Our ref: HA/2021/123283/01-L01
Your ref: P/68/21/PL
Date: 28 June 2021

**PART CHANGE OF USE OF EXISTING AMUSEMENT ARCADE TO MANAGERS
ACCOMMODATION (RESUBMISSION FOLLOWING P/48/20/PL)**

**PAGHAM BEACH AMUSEMENT ARCADE, 129 EAST FRONT ROAD, PAGHAM, PO21
4SX**

JJR DESIGNS Limited

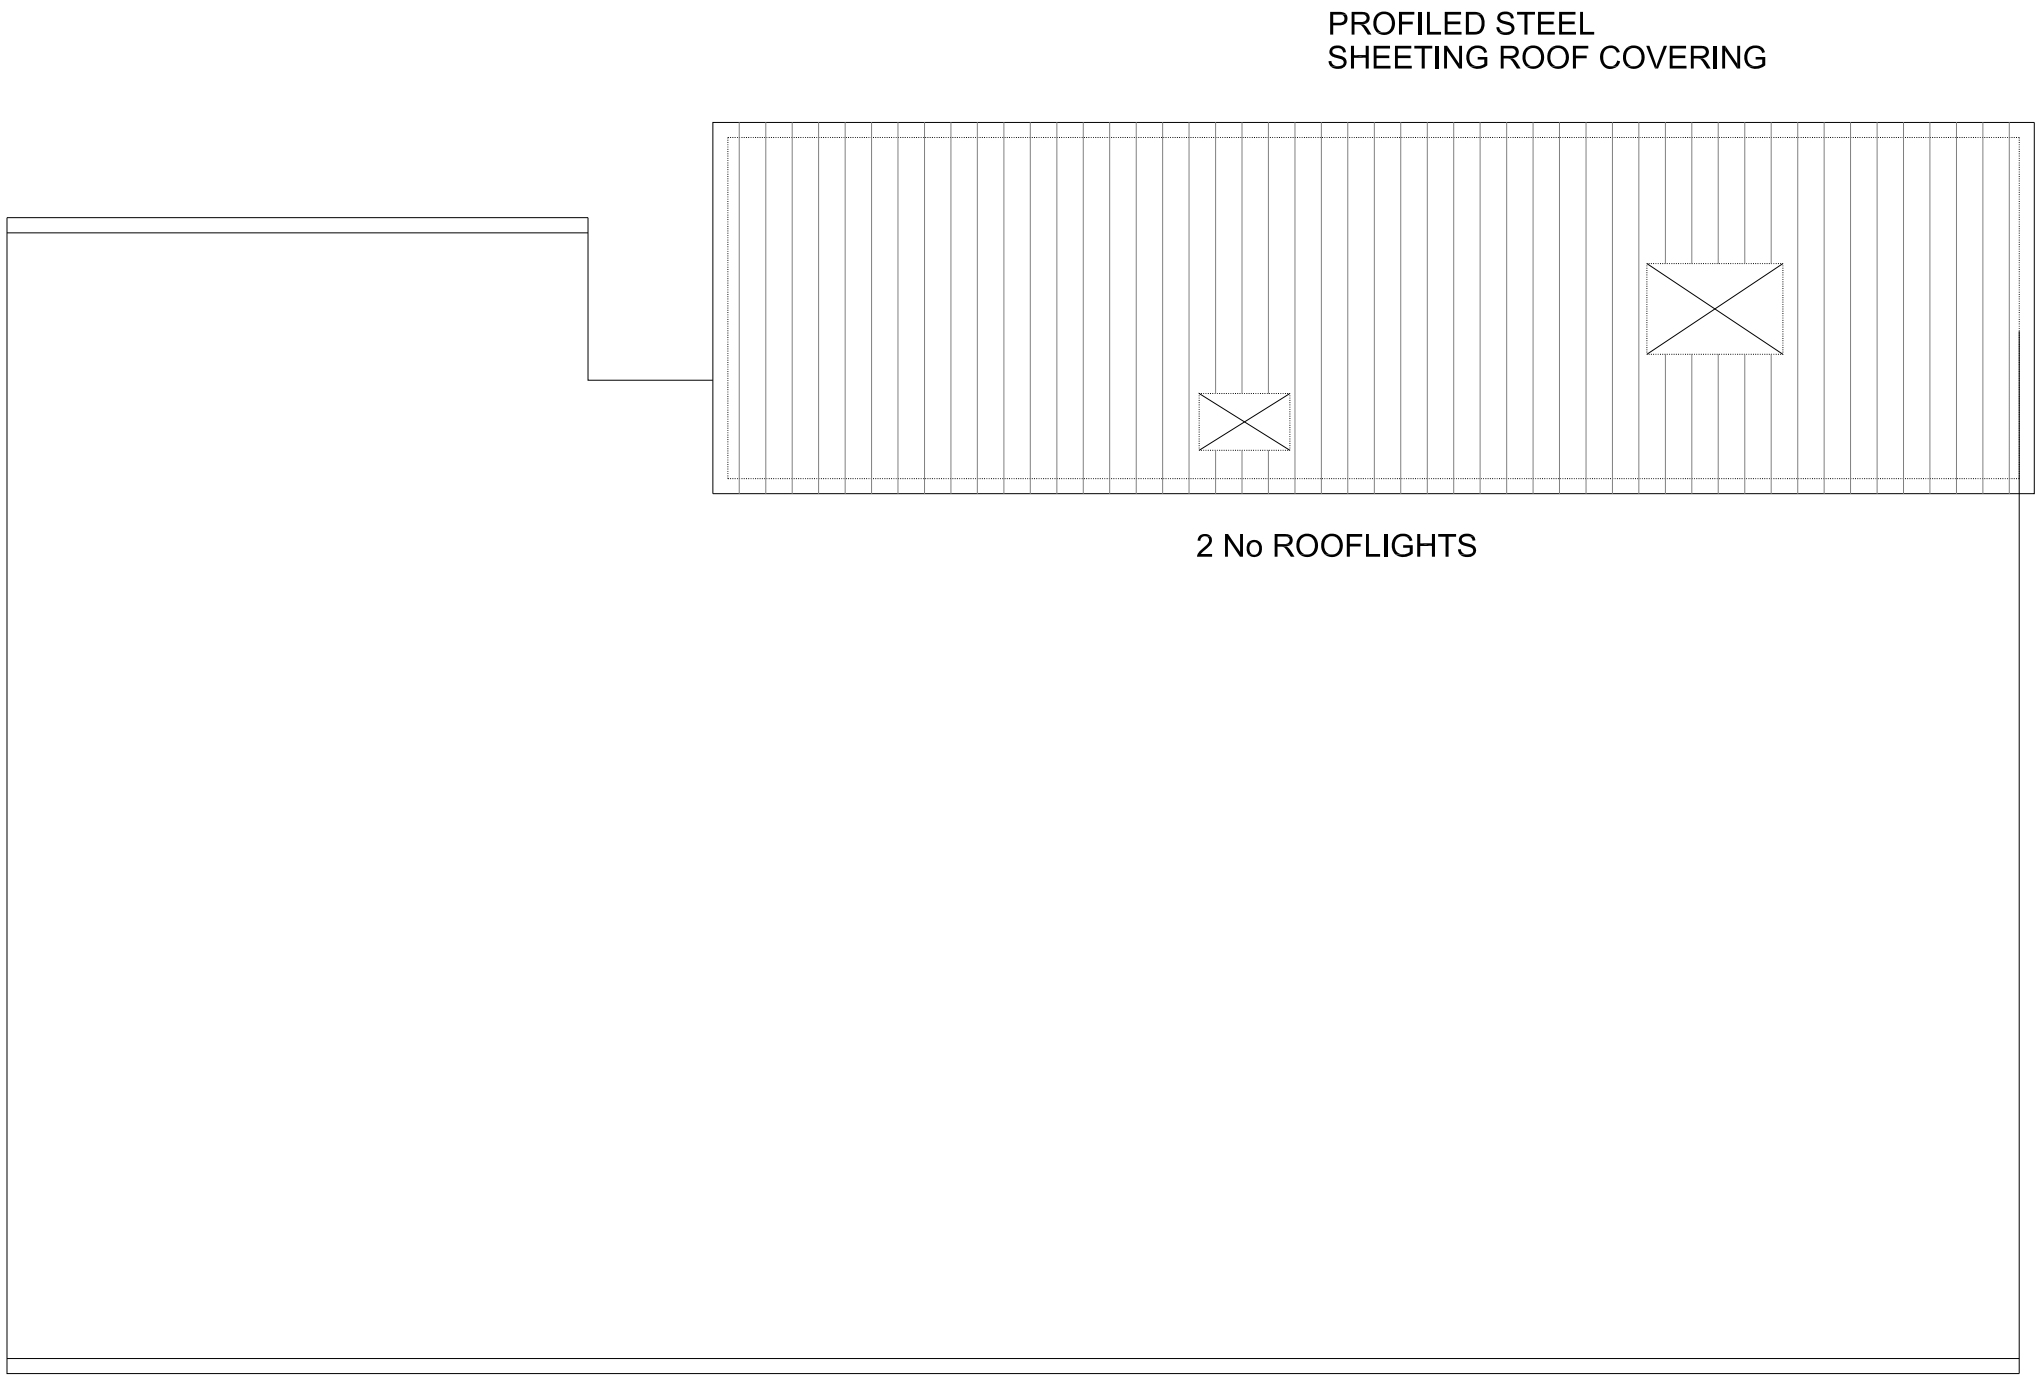
The submitted FRA does not comply with the requirements for site-specific flood risk assessments, as set out in paragraphs 30 to 32 of the Flood Risk and Coastal Change section of the planning practice guidance. The FRA does not therefore adequately assess the flood risks posed by the development. In particular, the FRA fails to:

- Take the impacts of climate change into account and provide a comparison between finished floor levels and modelled flood levels
- Consider how a range of flooding events (including extreme events) will affect people and property
- Consider the requirement for flood emergency planning including flood warning and evacuation of people for a range of flooding events up to and including the extreme event

We would recommend that sleeping accommodation is placed at least 300mm above the modelled flood levels (0.5% plus climate change allowances 2125), reducing the risk to occupants for the lifetime of the development.

To overcome our objection, the applicant should submit a revised FRA and amended plans which addresses the points highlighted above.

If this cannot be achieved, we are likely to maintain our objection. Please re-consult us on any revised FRA submitted and we'll respond within 21 days of receiving it.
